Date 2nd February 2021

RE: Richmond Arms 224 London Road Bognor Regis PO21 1AU

Thank you for your correspondence of the 2nd February 2021, advising me of a planning application for Approval of reserved matters following BR/142/18/OUT for the demolition & conversion of existing public house with residential accommodation to 1st floor to form 10 No. residential flats over 3.5 storeys at the above location, for which you seek advice from a crime prevention viewpoint.

Drawing Title:
PROPOSED FLOOR PLANS

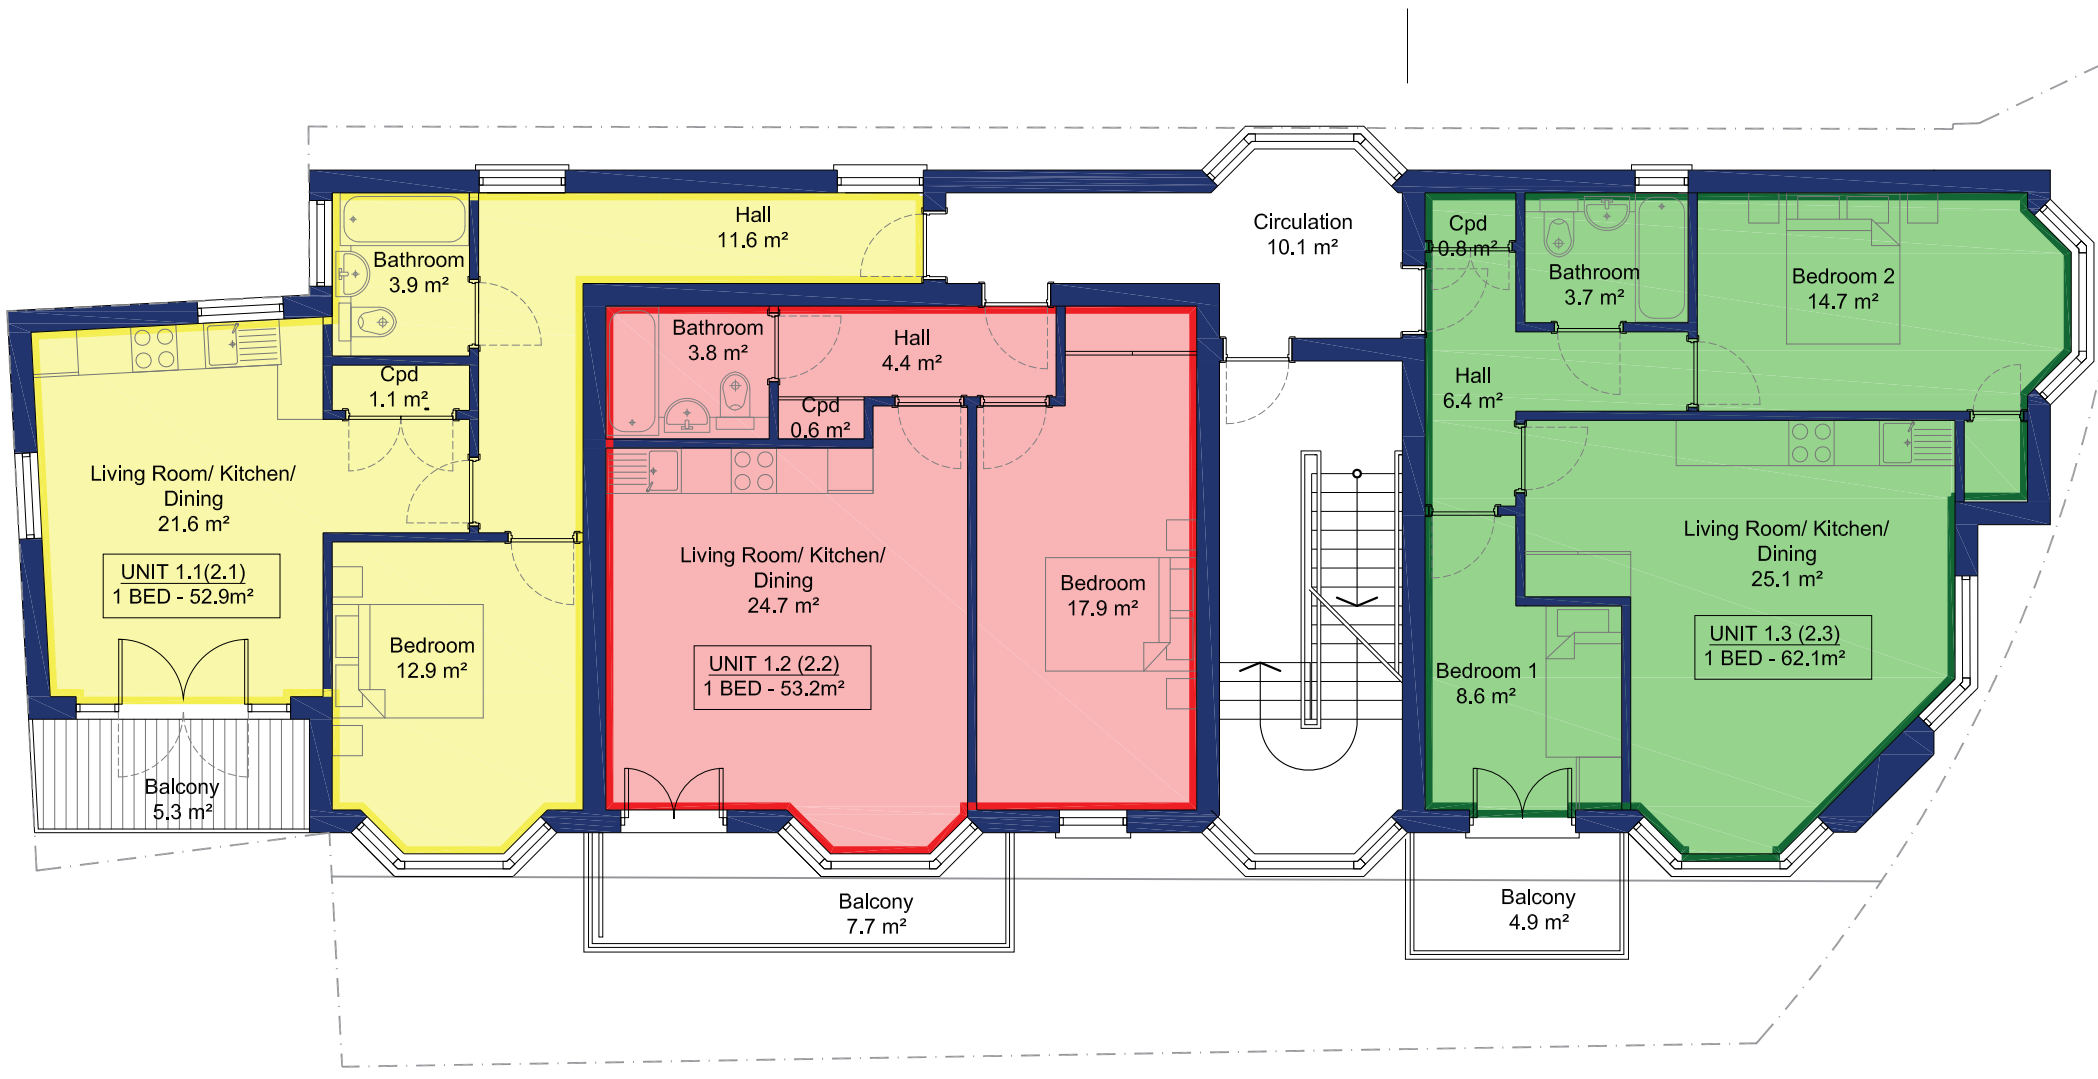
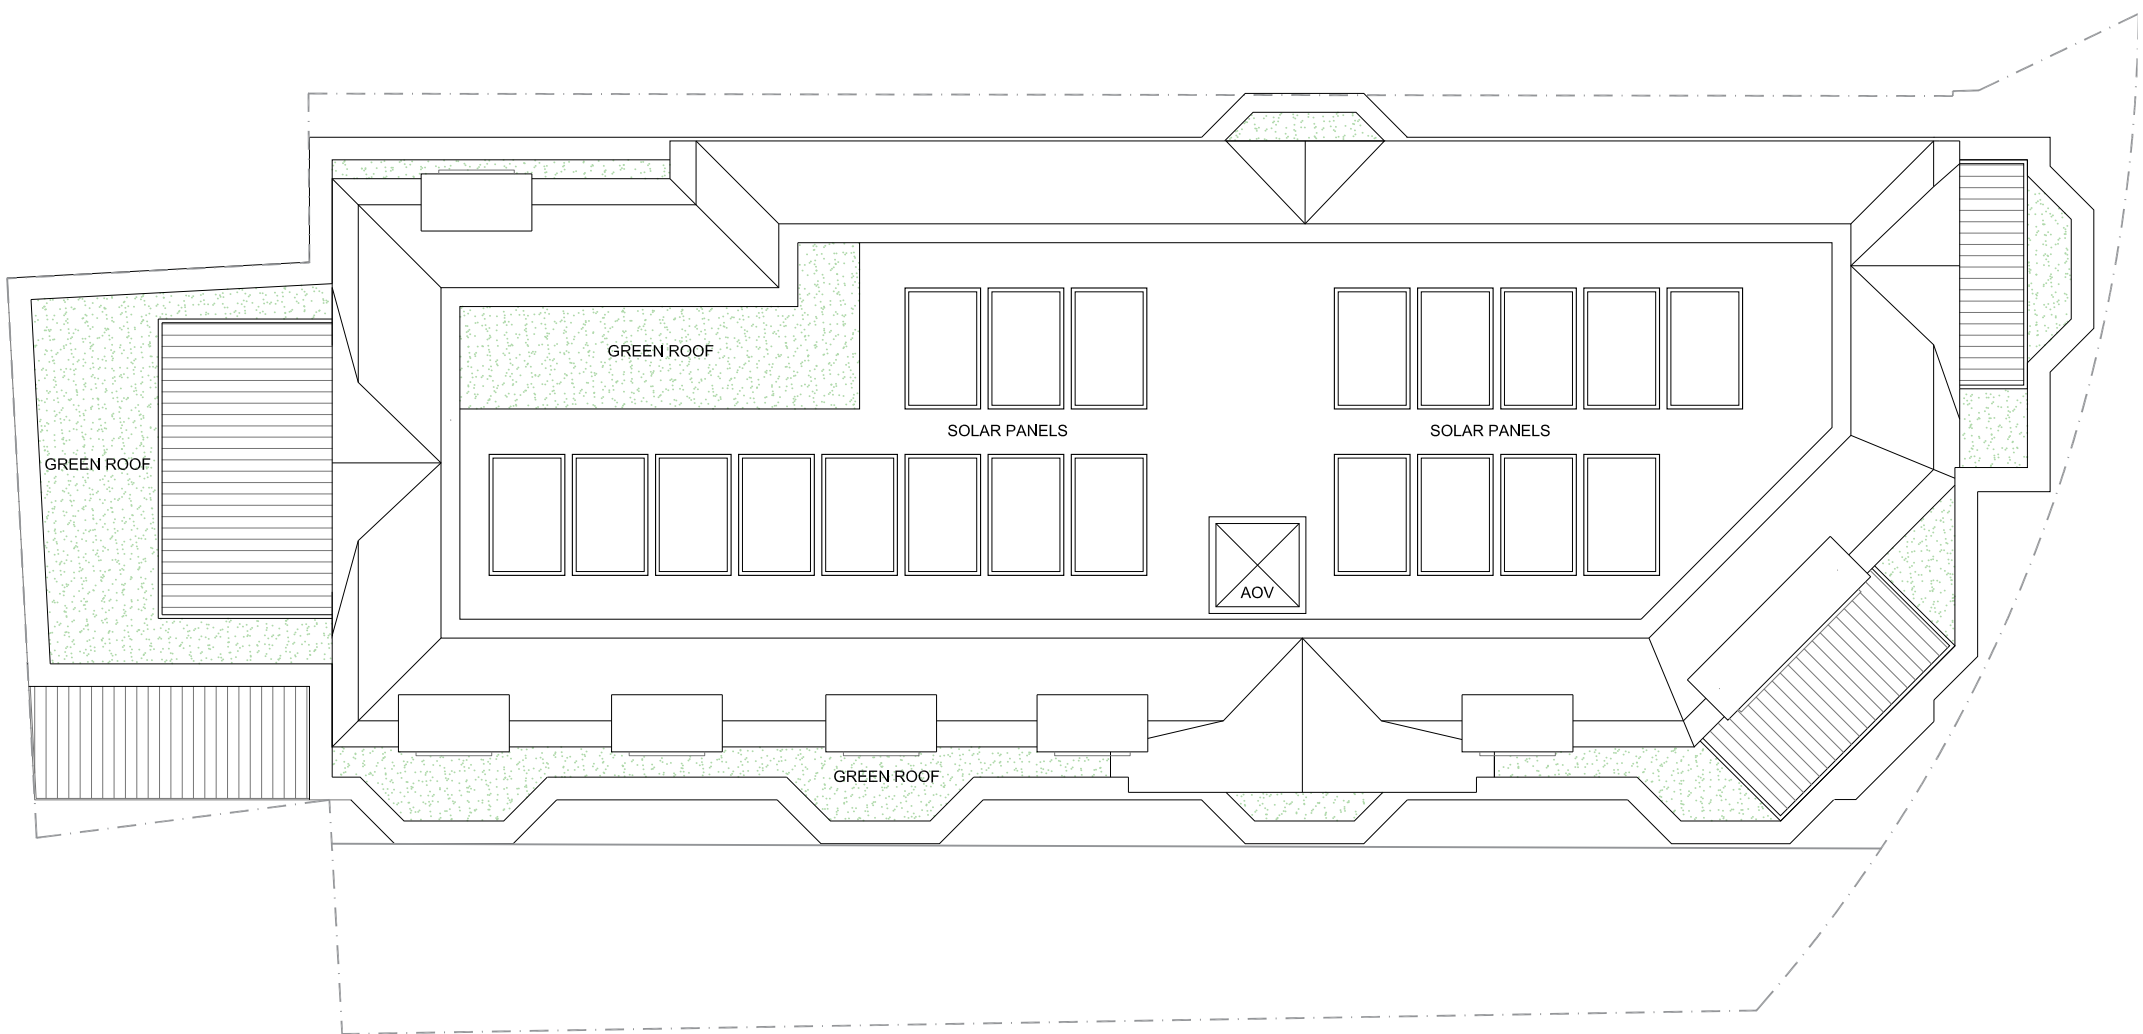
From a crime prevention perspective, it will be imperative that access control is implemented into the design and layout to ensure control of entry is for authorised persons only. SBD recommends that all communal door-sets serving 10 or more dwellings or bedrooms should have visitor door entry system or access control system to enable management oversight of the security of the building i.e. to control access to the building via the management of a recognised electronic key system. It should also incorporate a remote release of the primary entrance door set and have audio visual communication (preferably colour) between the occupant and the visitor. Door sets that are fitted with electronic locks or electronic staples must form part of the manufacturers certified range of door sets. Tradesperson or timed release mechanisms are not permitted as they have been proven to be the cause of antisocial behaviour and unlawful access to communal developments.

Additionally, I recommend the postal arrangements for the flats is through the wall or externally mounted secure post boxes. I strongly urge the applicant not to consider letter apertures within the flats' front doors. The absence of the letter aperture removes the opportunity for lock manipulation, fishing and arson attack and has the potential to reduce unnecessary access to the block.

I recommend that all balconies are provided with balustrades sufficiently high to deter and prevent persons from falling or climbing over the top of them.

Drawing Title:
PROPOSED SITE PLAN

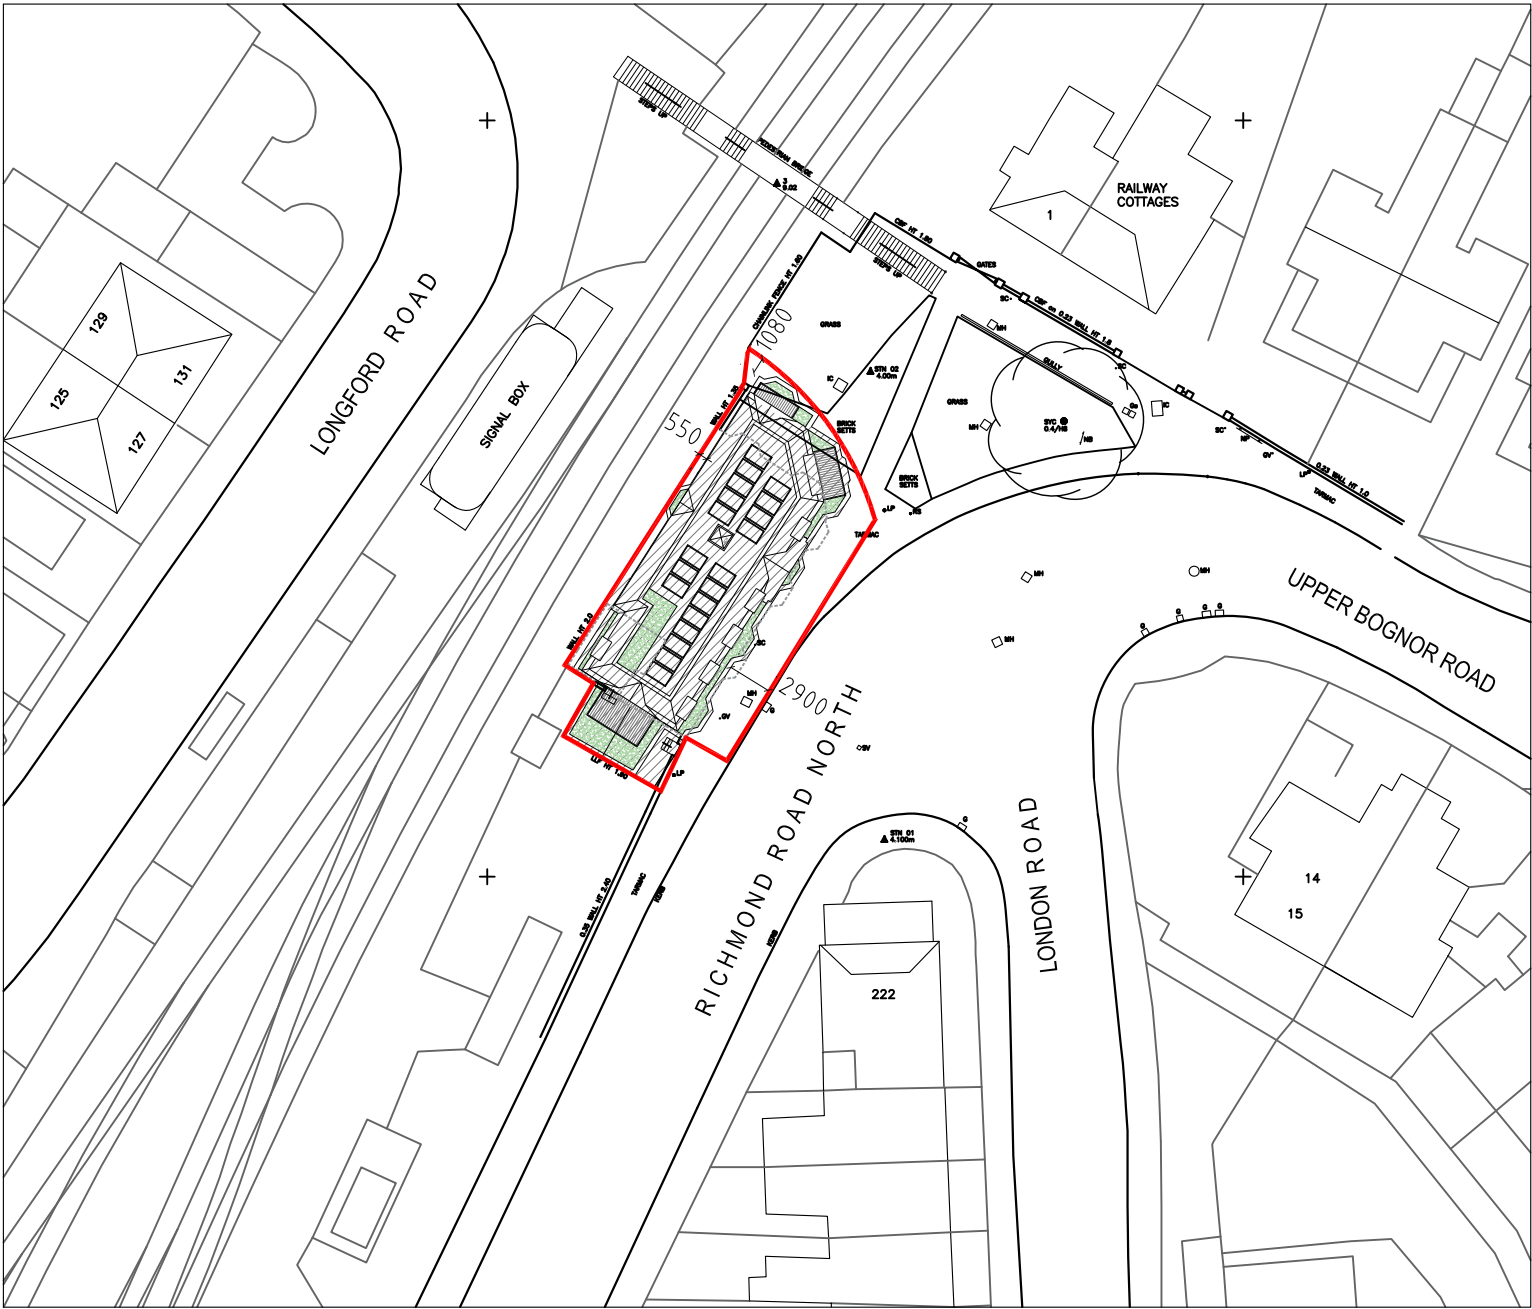
With regards to both cycle and bin stores I refer the applicant to SBD Homes 2019 Chapter 57 57:1 through to 57:3. This chapter will give the applicant additional information pertaining to security to these areas.

Any ground planting should not be higher than 1 metre with tree canopies no lower than 2 metres. This arrangement provides a window of observation throughout the area.
